**KIRKLEES METROPOLITAN COUNCIL
INVESTMENT & REGENERATION SERVICE**

Reference No:	2025/60/91236/E
Site Address:	Land off, Stocks Moor Road, Stocks Moor, Huddersfield, HD4 6XQ
Description:	Outline application for erection of residential development (one dwelling) with all matters reserved
Recommending Officer:	Kerri Simpson

DECISION – REFUSAL

Officer Report – 2025/91236

PROPOSED SITE PLAN

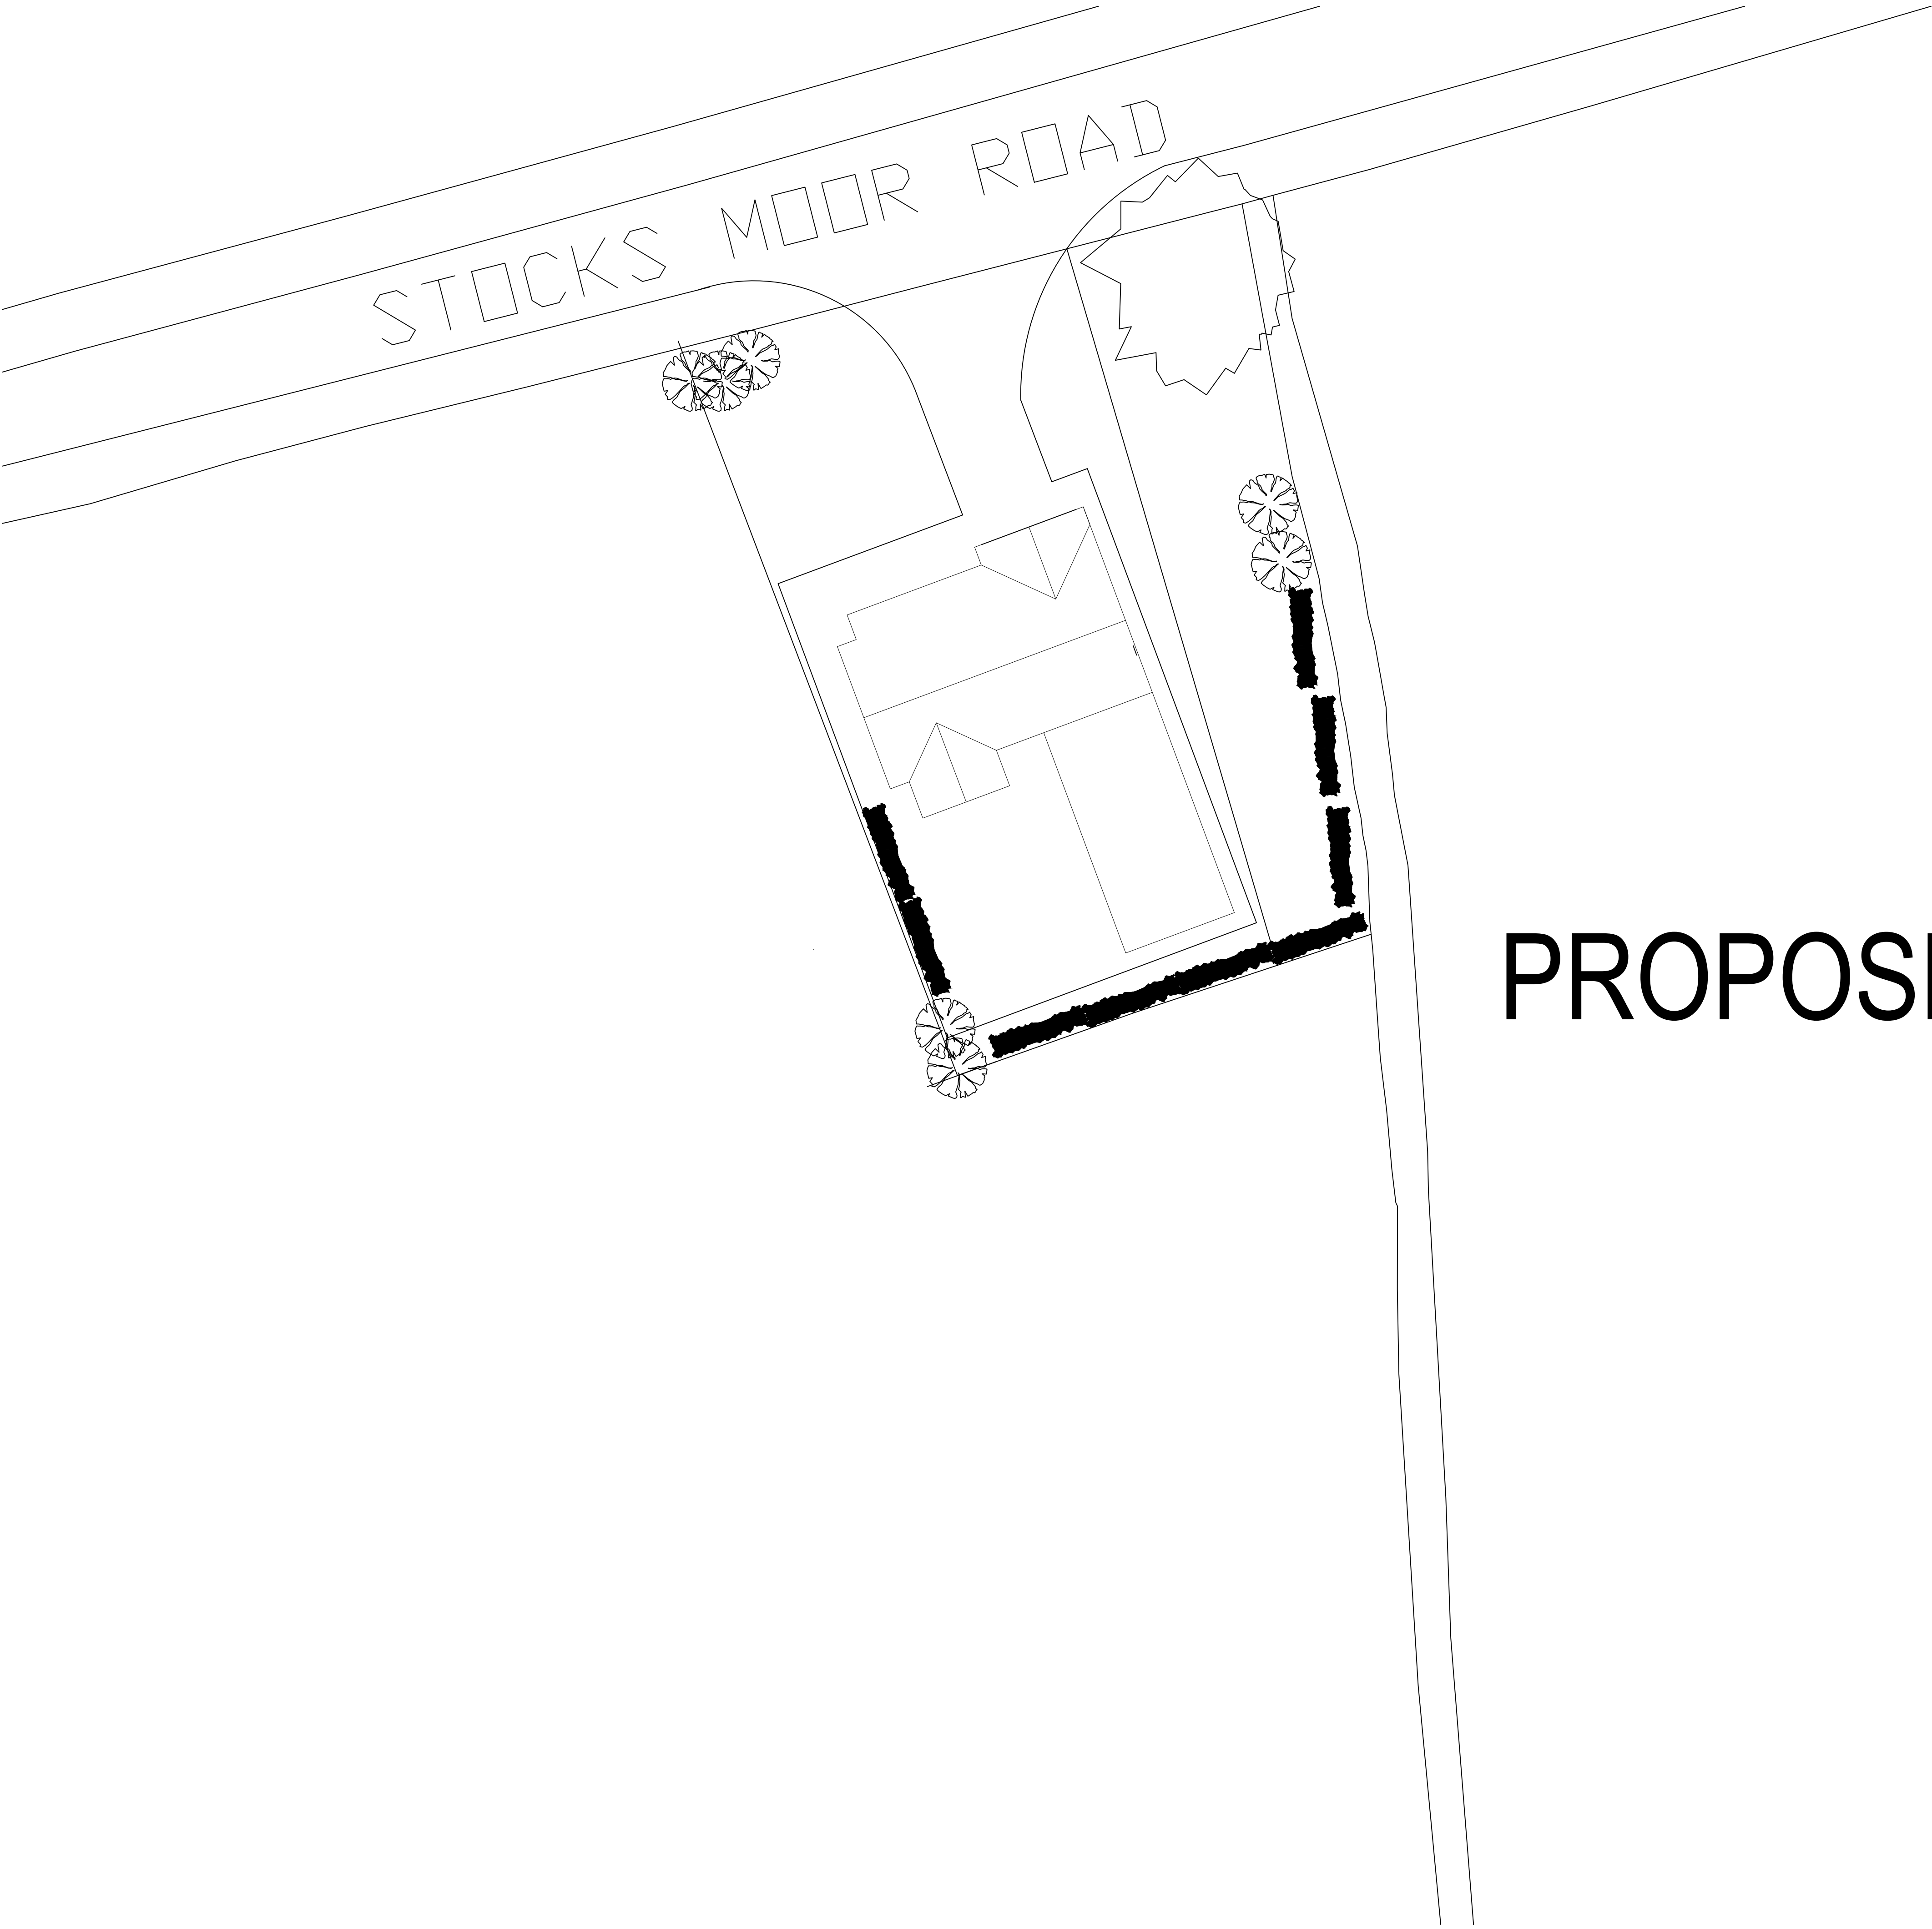
The applicant is seeking outline planning permission with all matters (access, layout, scale, appearance & landscaping) being reserved. The proposal is to establish the principle of development for one dwelling on the site. The proposed access would be from Stocks Moor Road. An indicative proposed site plan has been submitted showing the proposed access in situ with a detached dwelling set back from the highways with vegetated boundaries.

The proposed development would introduce a detached dwelling and associated domestic infrastructure into an open and visually exposed part of the rural landscape. The site currently forms part of a wider undeveloped field that contributes to the landscape setting of Stocksmoor and provides a clear transition between the built form of the village, tight clusters of dwellings and the surrounding countryside. The indicative layout shows a centrally positioned dwelling with boundary treatments, hardstanding, and domestic landscaping, none of which are present in the current greenfield context.

The introduction of built form engineered access, and suburban boundary features in this particular location would result in a visually discordant and

urbanising presence, disconnected from the nearby dwellings on Stocks Moor Road. It would appear dominant when viewed from Stocks Moor Road and surrounding vantage points. The development would disrupt the natural rural gain of the landscape, with no clear visual containment or defensible edge, and would lead to an erosion of local landscape character.

While landscaping is a reserved matter, it is acknowledged that boundary planting could, in theory, help soften the visual impact of development. However, in this case, the site is slightly elevated above the highway, with long views across open countryside. Given the scale of the open land surrounding the site, and the lack of existing vegetation on boundaries, any future planting would take time to establish to a degree that would fully mitigate the visual harm caused by introducing built form in this context and in itself appear less integral to the character of the area.

As such, it is considered that development in principle would fail to respect and enhance the character of its surroundings including the landscape, contrary to Policy LP24 of the Kirklees Local Plan and Paragraph 135 of the National Planning Policy Framework 2024.

The application has been submitted in outline with all matters reserved. The proposed access would be taken from Stocks Moor Road, serving a single dwelling positioned adjacent to the highway. No formal response has been received from the Council's Highways Development Management team on the proposal.

However, the application is seeking outline consent only, and it is noted it is within an area where an existing vehicular access exists already and was previously consented (application ref: 2019/90847). Upon the previous consent it was concluded the access achieved acceptable sightlines. Given this application not seeking access & layout at this stage, it is considered that ensuring adequate sightlines can be achieved is a matter that can be secured at the Reserved Matters stage.

It is considered that the principle of using the vehicular access would be acceptable on the basis adequate parking, turning and sightlines are demonstrated and this would be able to be revisited and ensured at the reserved matters stage given this application is outline with all matters reserved.
